From: James Kirkham
Sent: 17 June 2021 20:07
To: DC Support
Subject: FW: Planning notification for application reference: 21/01123/F

Thank you for your comments on this. I have just noticed that the Tree retention and protection plan appears to be based on the old layout. The new layout of the site now includes parking under the large lime trees on the eastern boundary (if you look at the overall site plan). Could you please clarify if this alters your comments or if you are satisfied the parking can be provided without damage to the trees?

Proposal – Construct replacement buildings

DRAWING TITLE	- Proposed Site Plan - Overall		
CONTRACT	- The Hatchery		
MODELLED BY	- HS	ISSUE DATE	- 10.09.21
CONTRACT NO	- JOB139990	SCALE	- 1:500 @A1
DRAWING No	- 139990_P102	REVISION No.	E

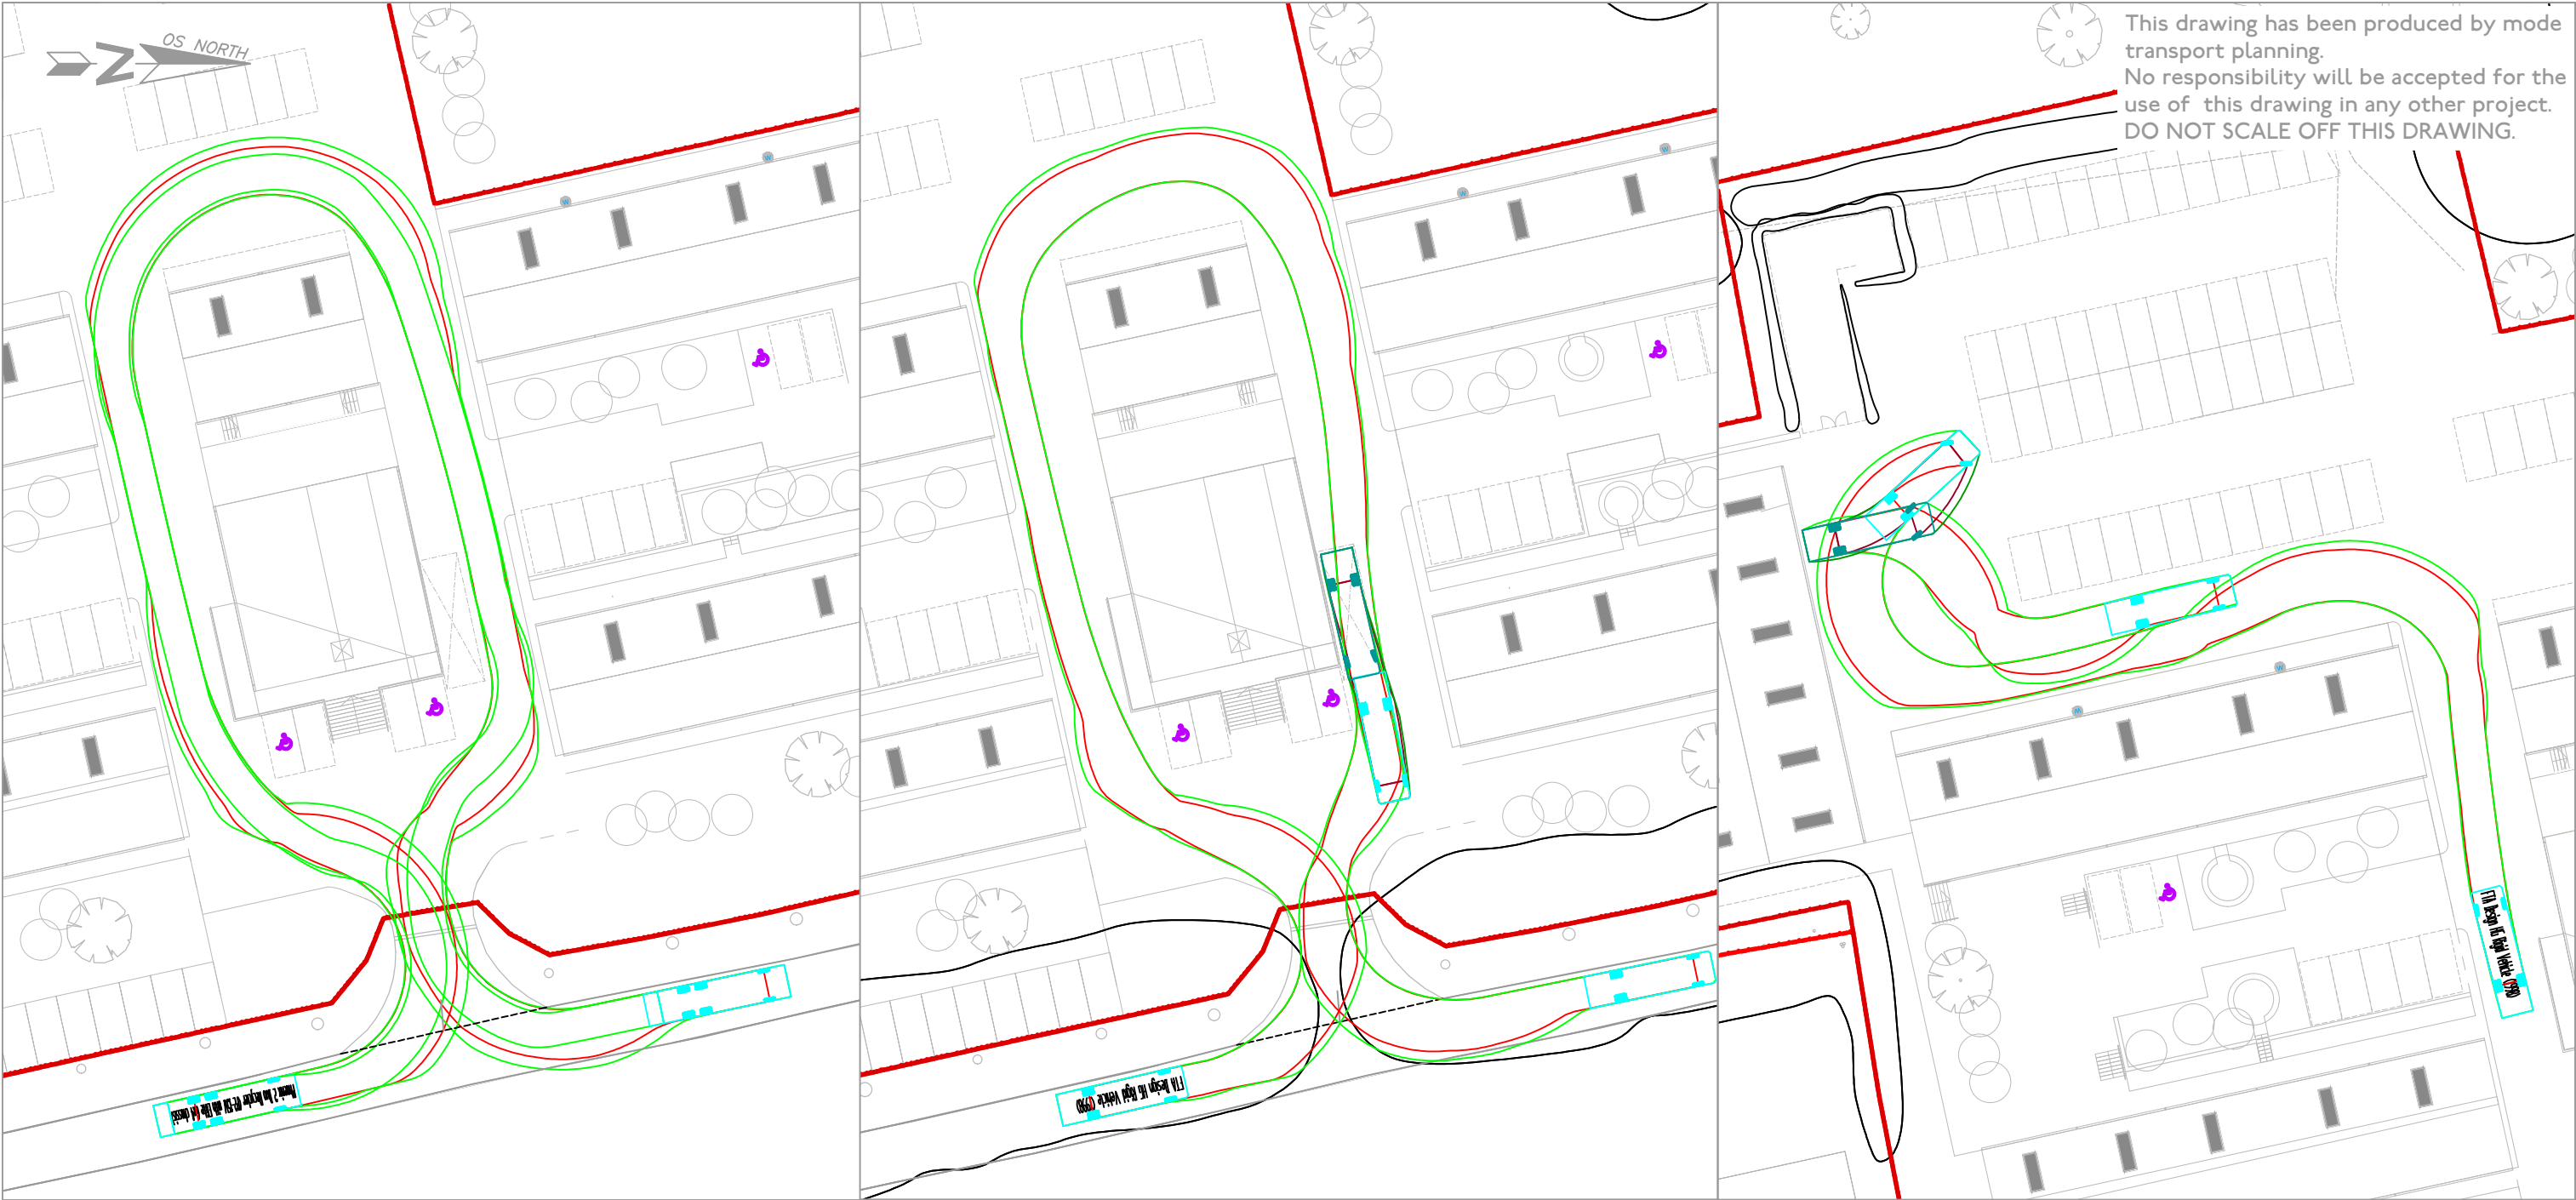
Also do you have any concerns placing parking under lime trees leading to long term pressure for removal? My understanding is these trees can result in sticky residue.

So an updated Arboricultural report is required and you can make a comment about the proposed parking under lime trees which will be dropping honey dew.
